**NEWARK &
SHERWOOD**
DISTRICT COUNCIL

WRITTEN REPRESENTATIONS

A46 NEWARK BYPASS

SUBMISSION AS THE LOCAL PLANNING AUTHORITY

DRAWING TITLE
 Figure 2.2
 Environmental Constraints Plan
 Sheet: 3 of 4

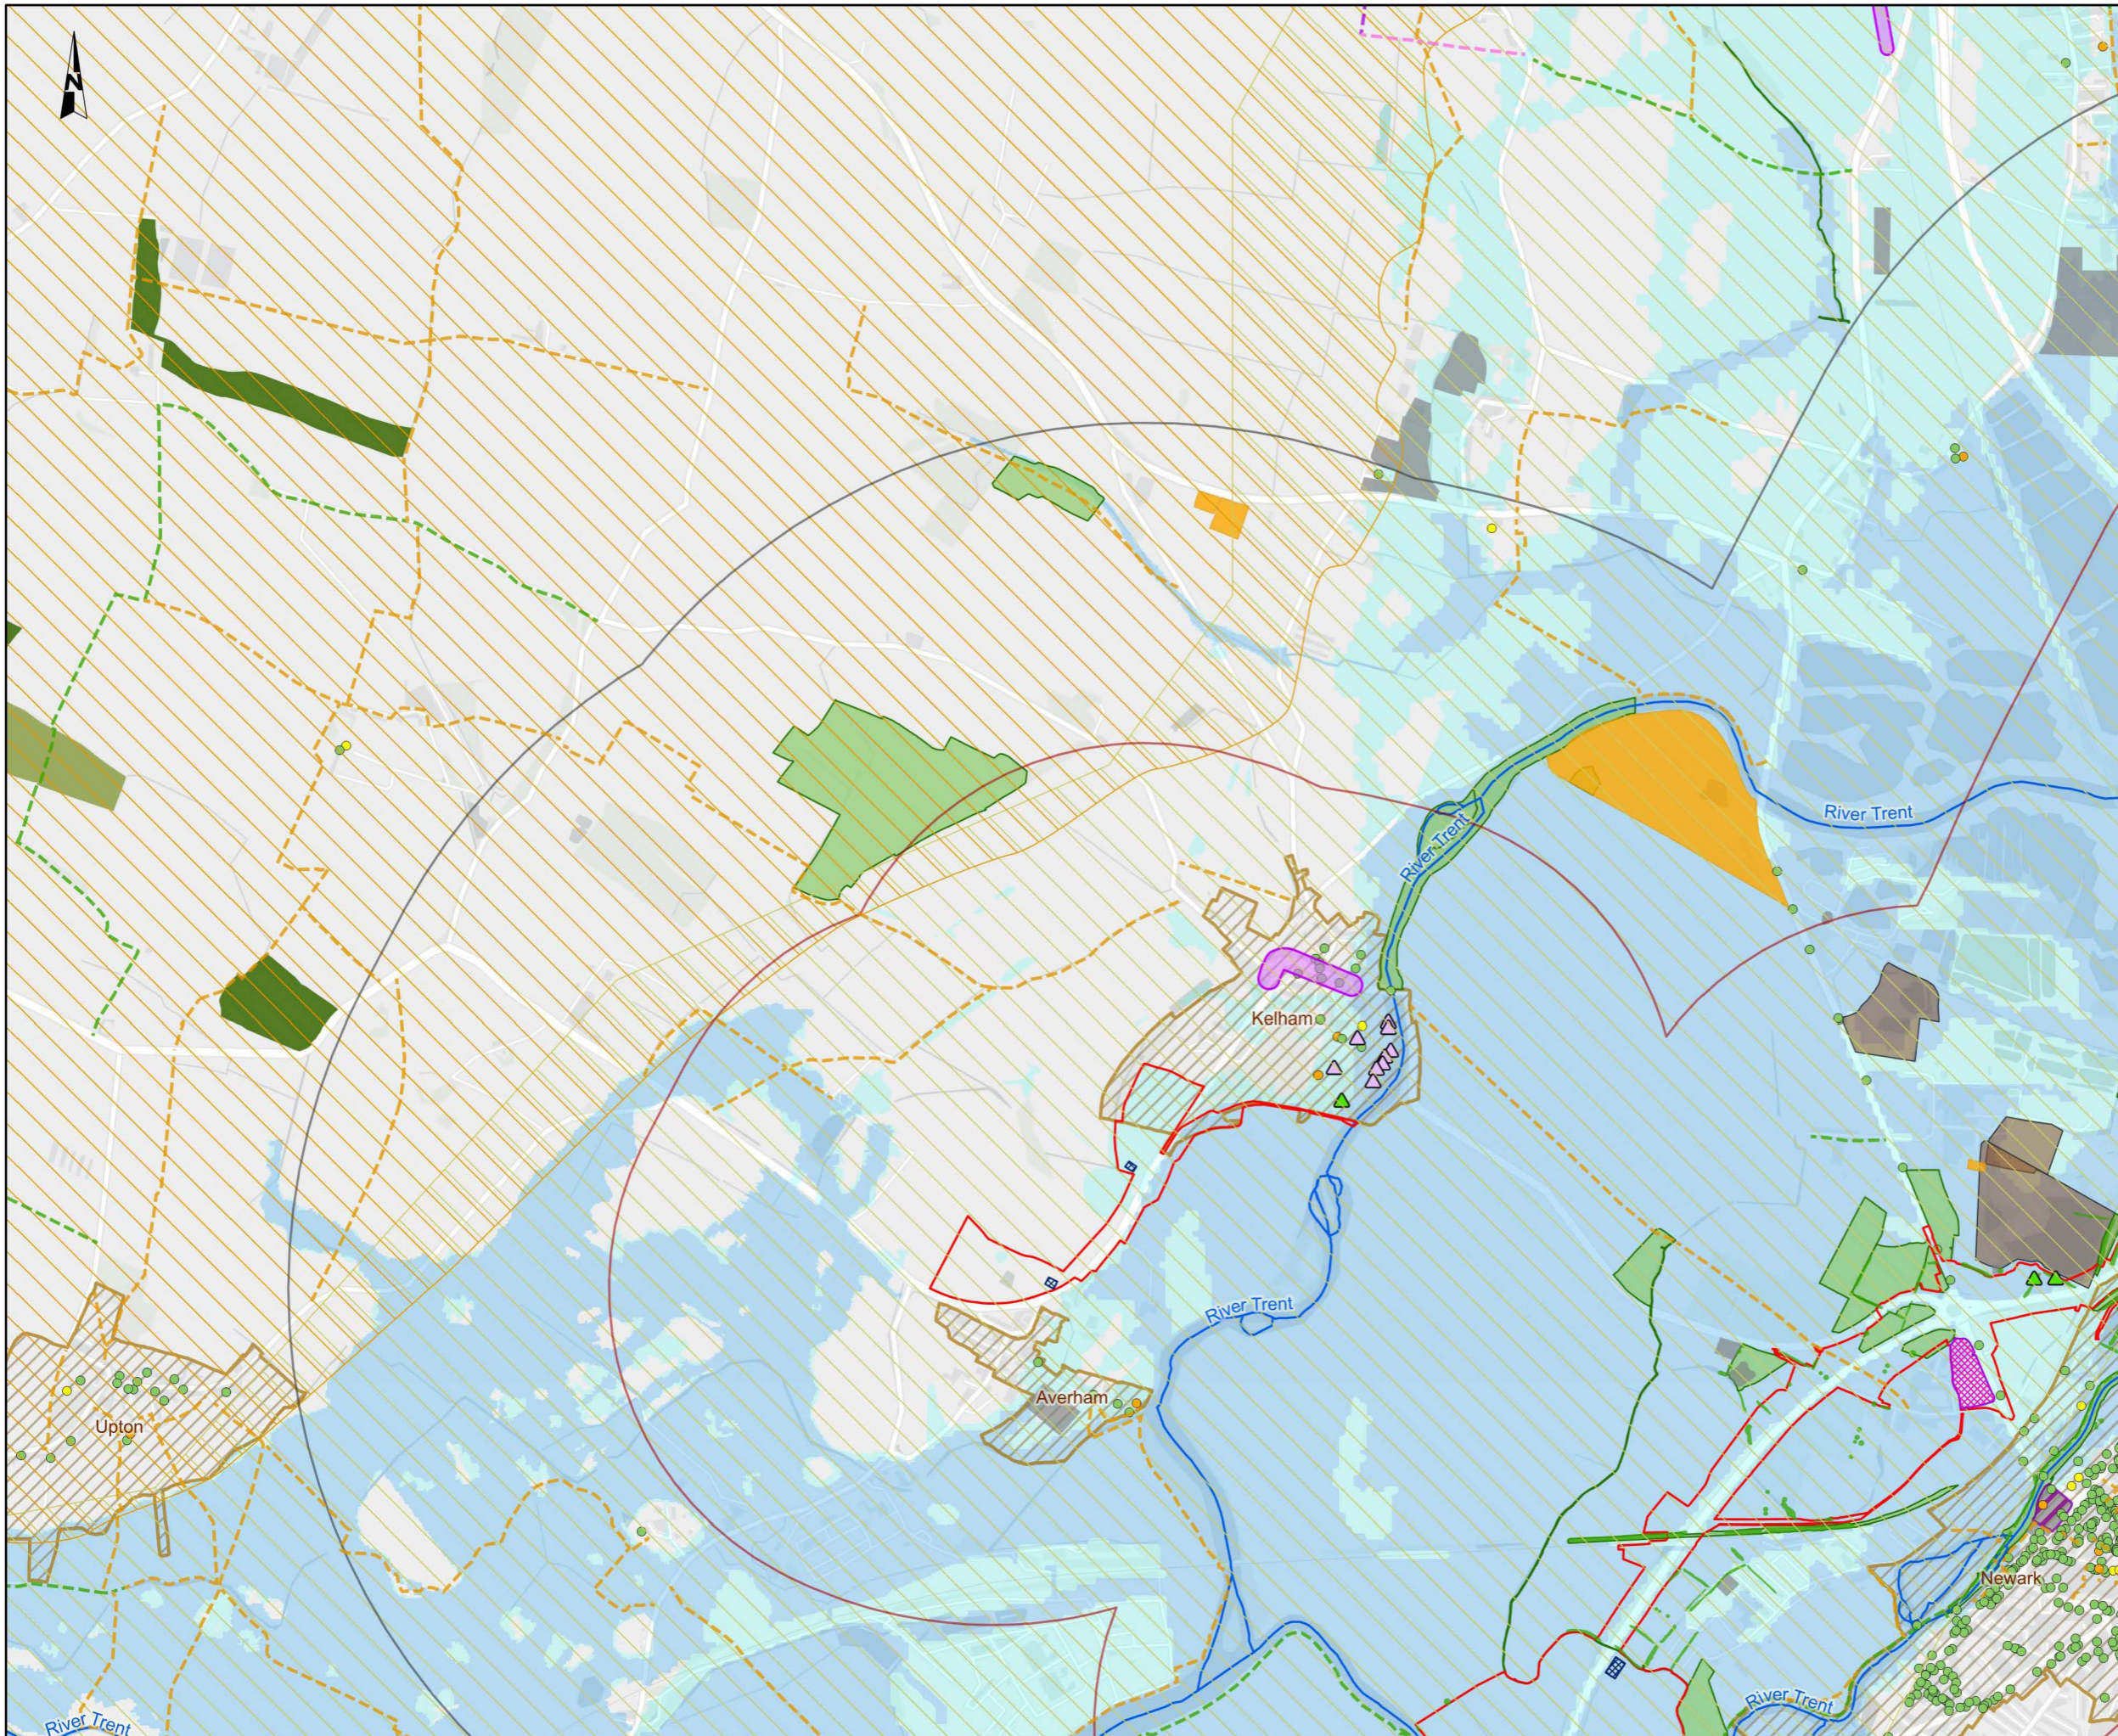
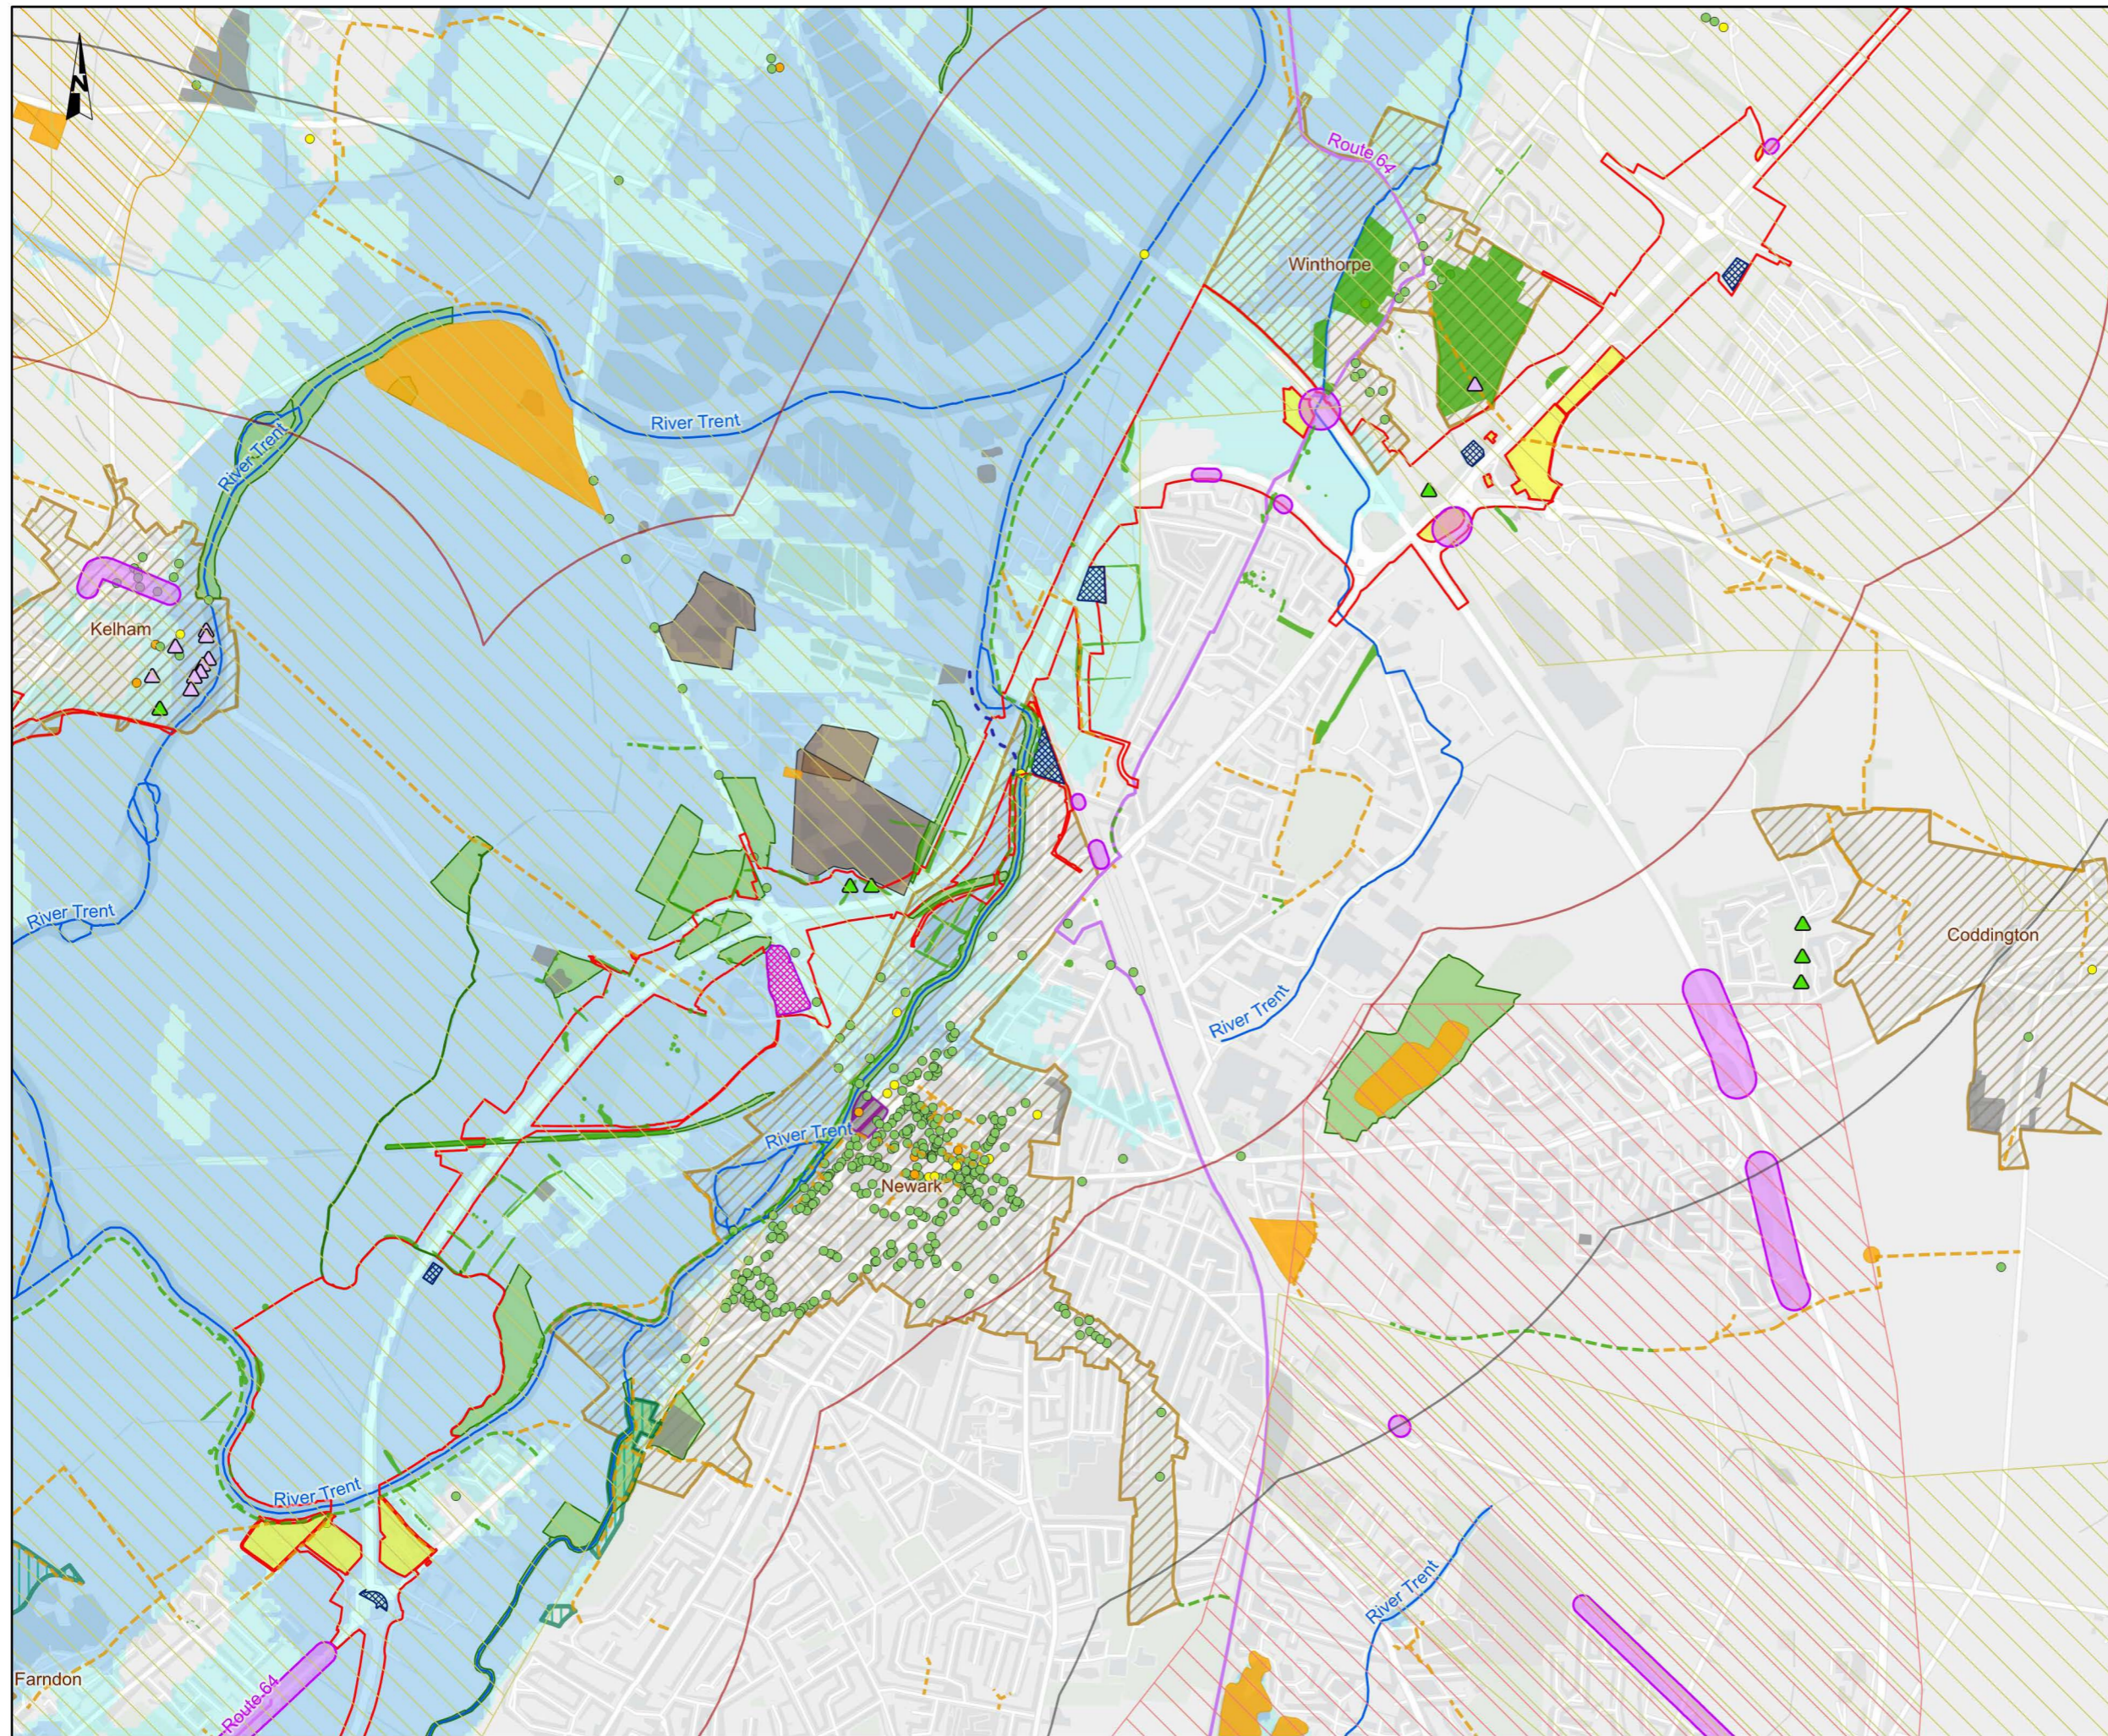
- The applicant has not identified all key designations that contribute to Landscape Character or visual matters which include nature conservation sites. These designations haven't been listed in Table 7.6. though they have been identified on the Constraints Plan Figure 2.2 Environmental Constraints Plan. These should be included within Chapter 7 Landscape and Visual Effects assessment;
